Appendix A – Response to DPHI RFI

Table 1 Response to matters raised by Department of Planning, Housing and Infrastructure (DPHI)

Drawing Name
 ENVELOPE CONCEPT
 SSDA - PLAN

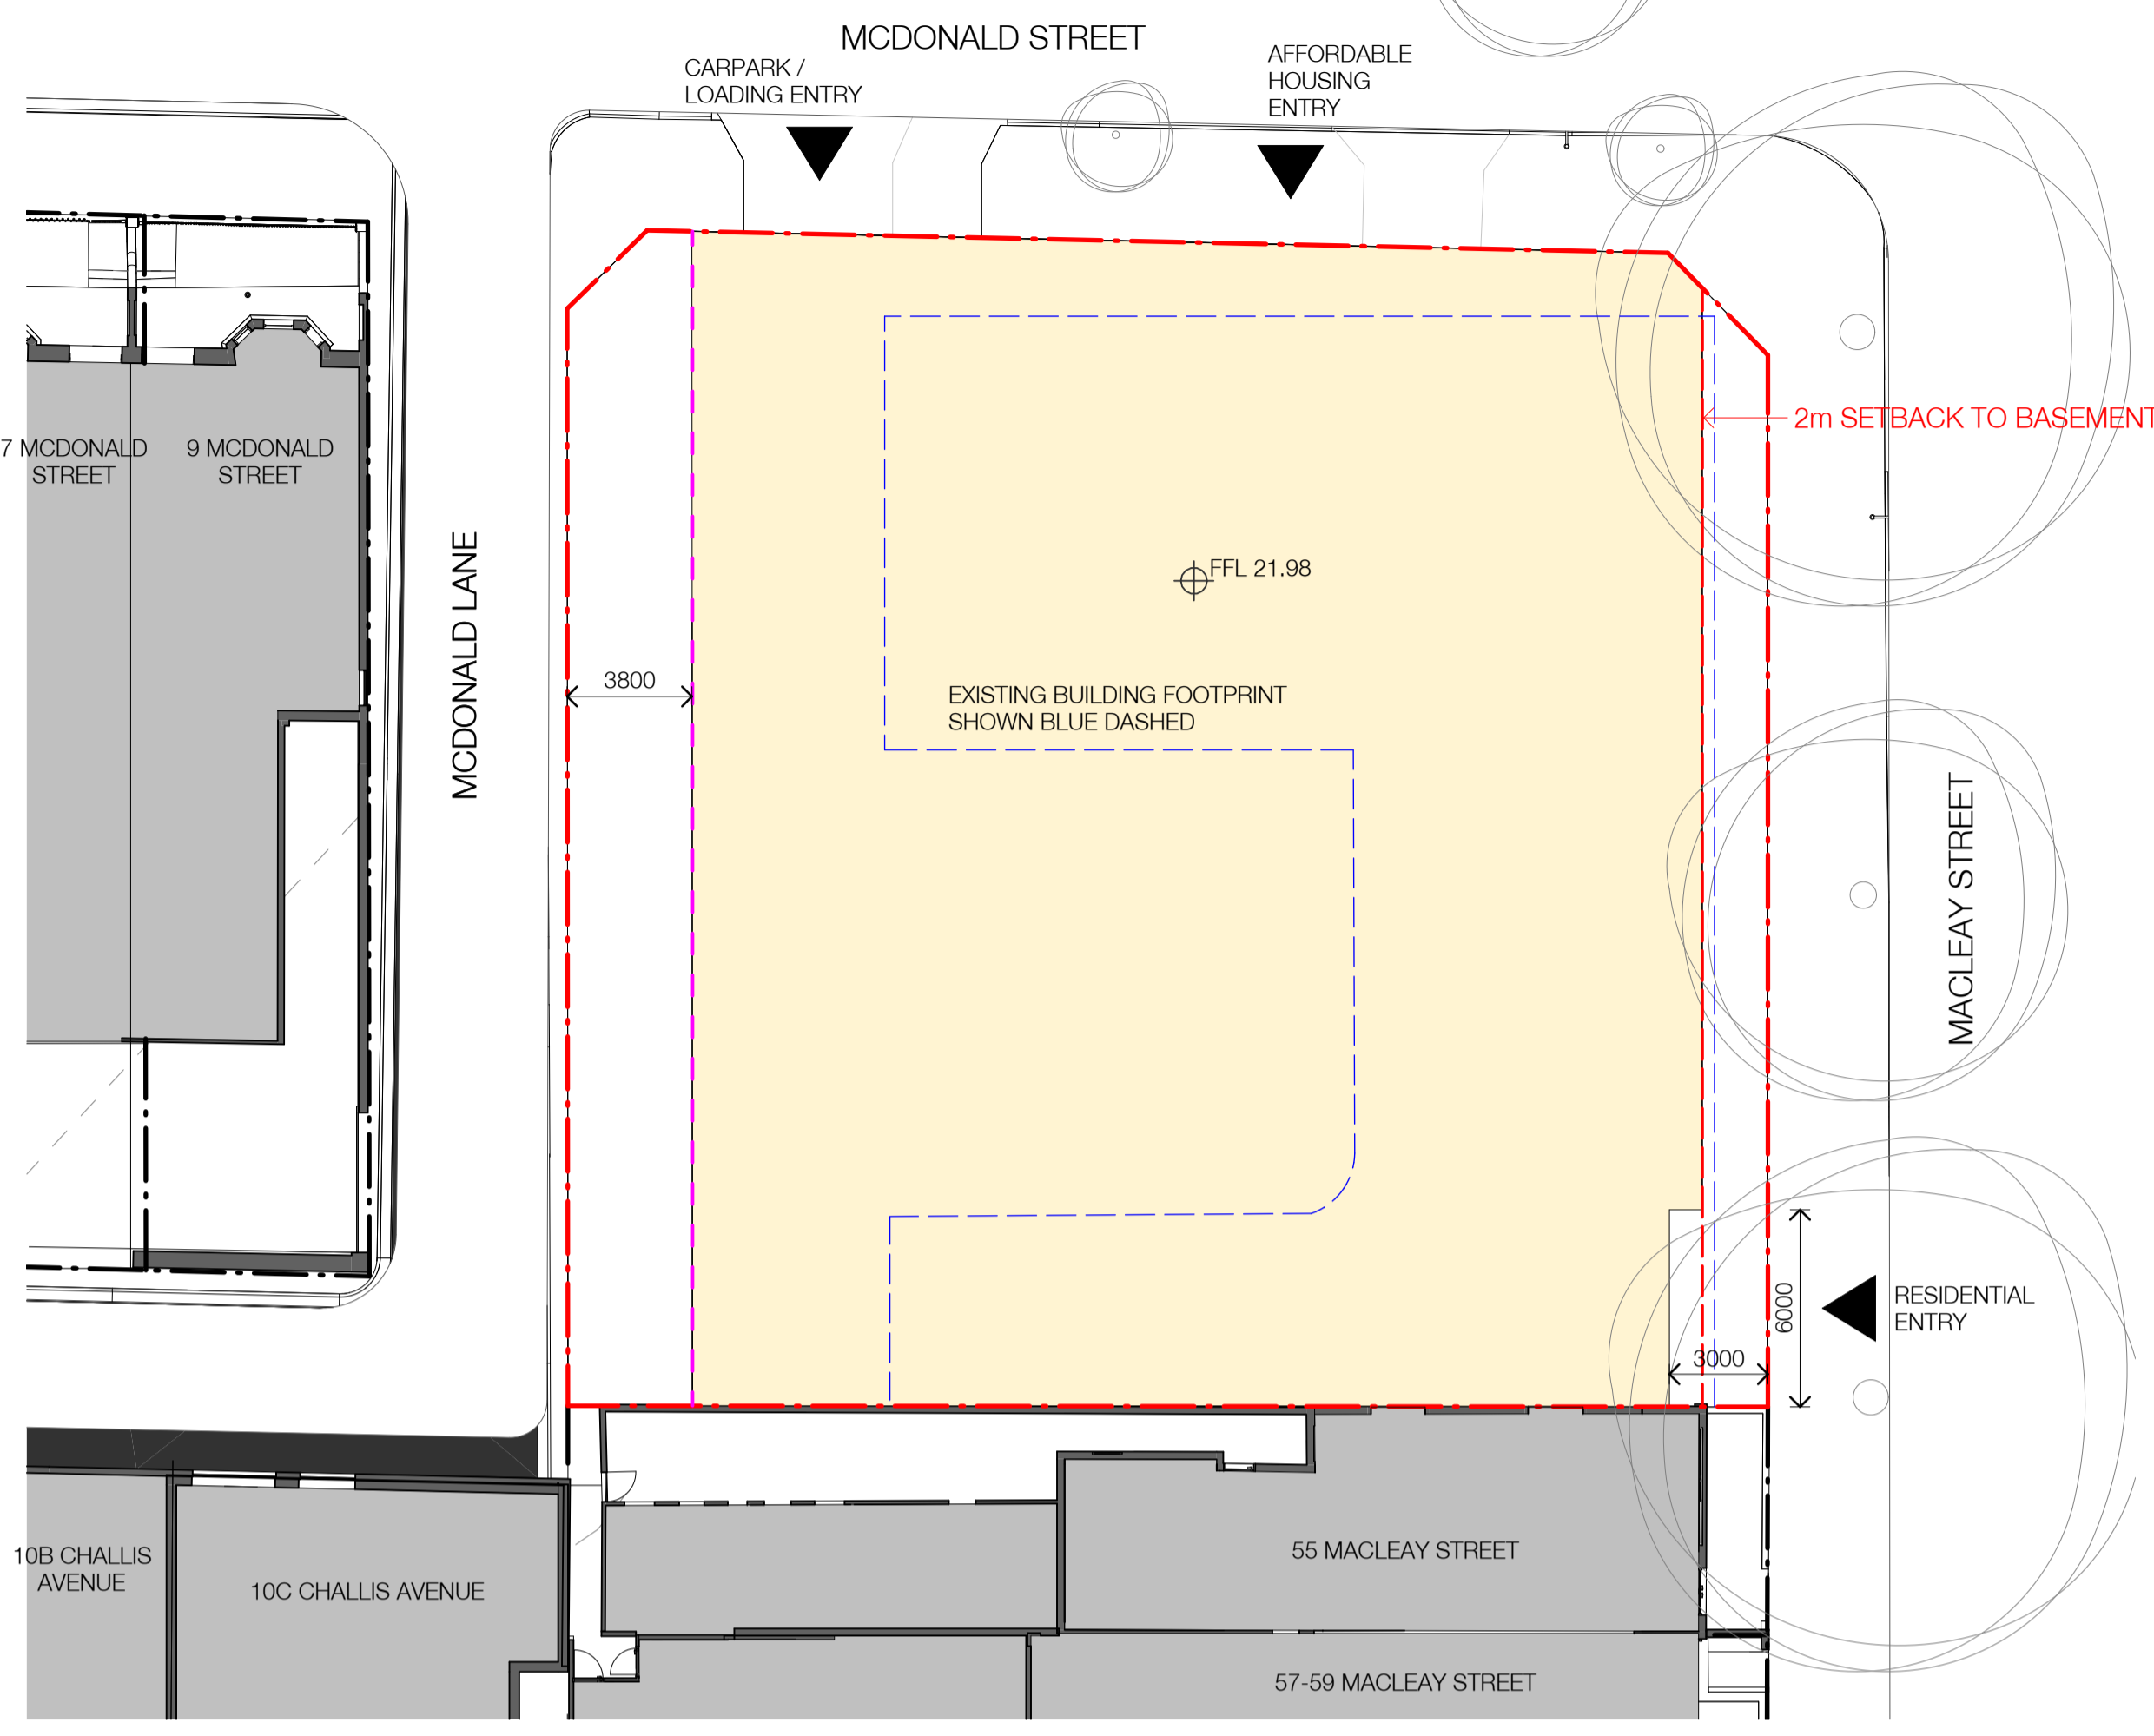
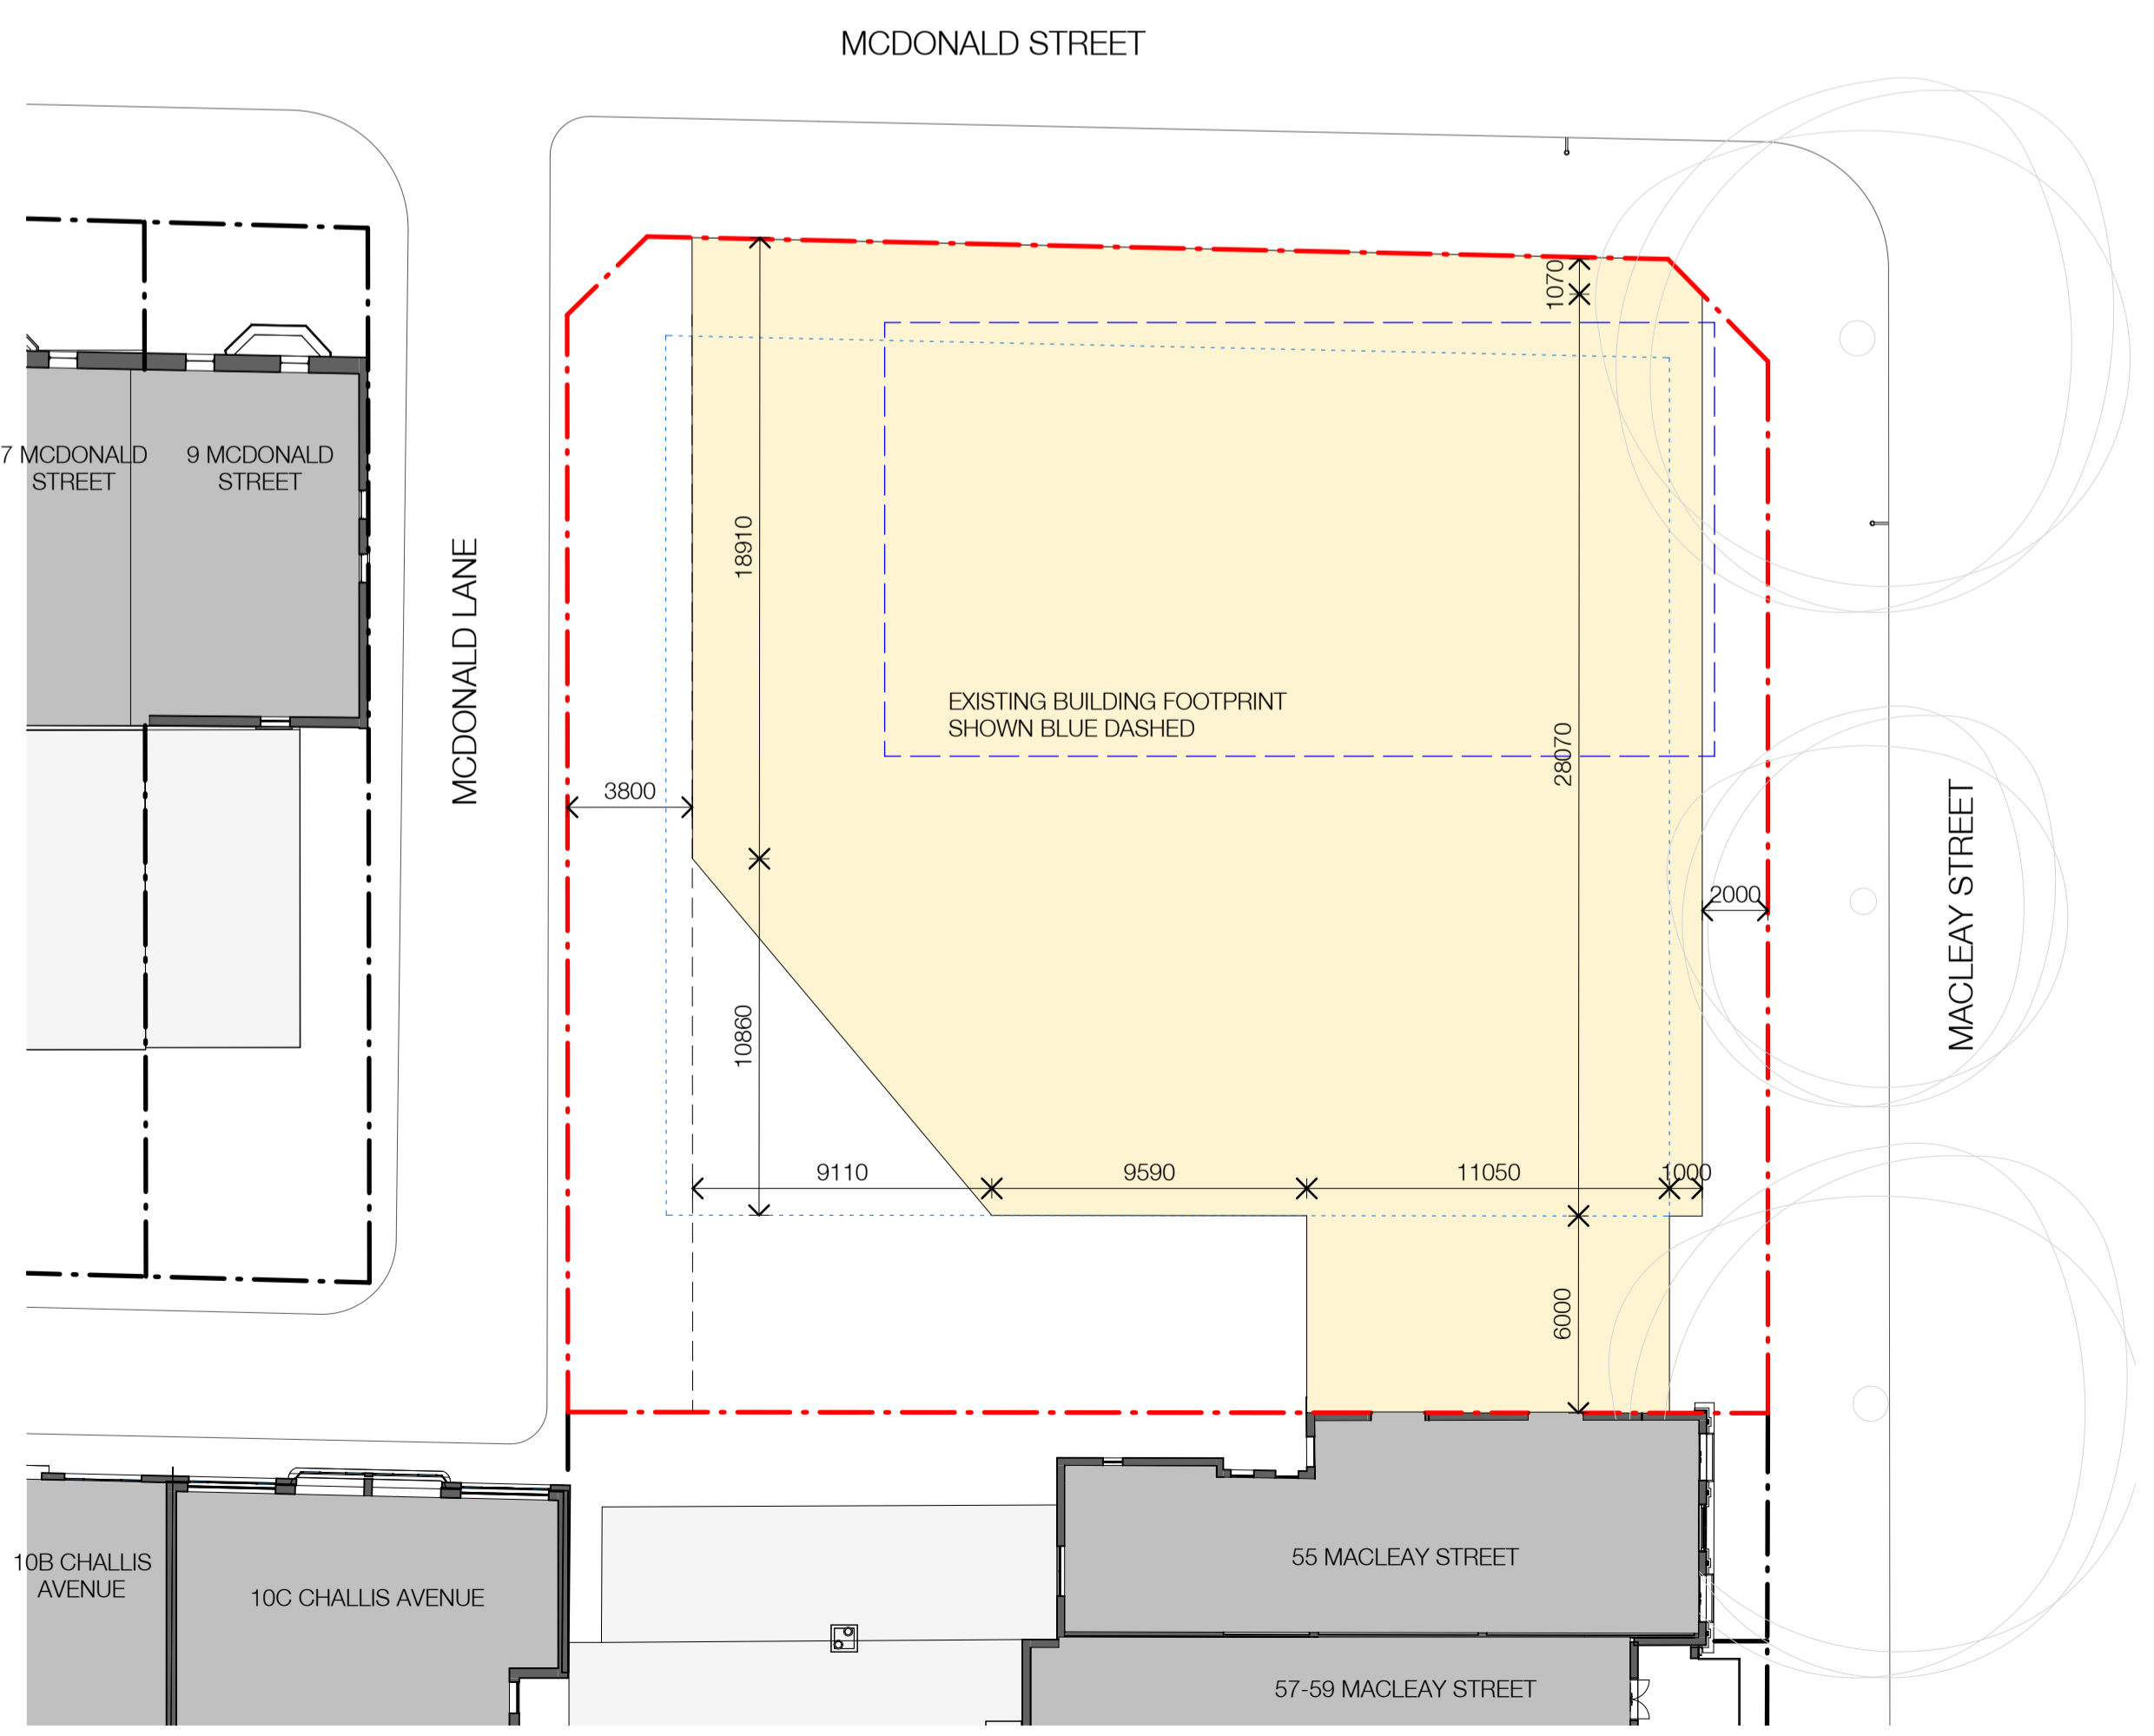
(b) Indicate the location and area of deep soil zones on the site plan.	The deep soil zone is proposed to be located along McDonald Lane and has been depicted in the updated Site Plan at Appendix B.	Appendix B
(c) Align the basement setbacks between the site plans and elevations. Specifically, the 2m eastern setback and the 3.8m western setback to the basement depicted on the site plan are not accurately depicted on the elevations.	The envelope elevation plans have been updated to show the basement setbacks at Appendix B.	Appendix B
(d) Detail the street names/frontages on the height plan diagrams.	Amended height plane diagrams containing street names have been provided at Appendix B.	Appendix B
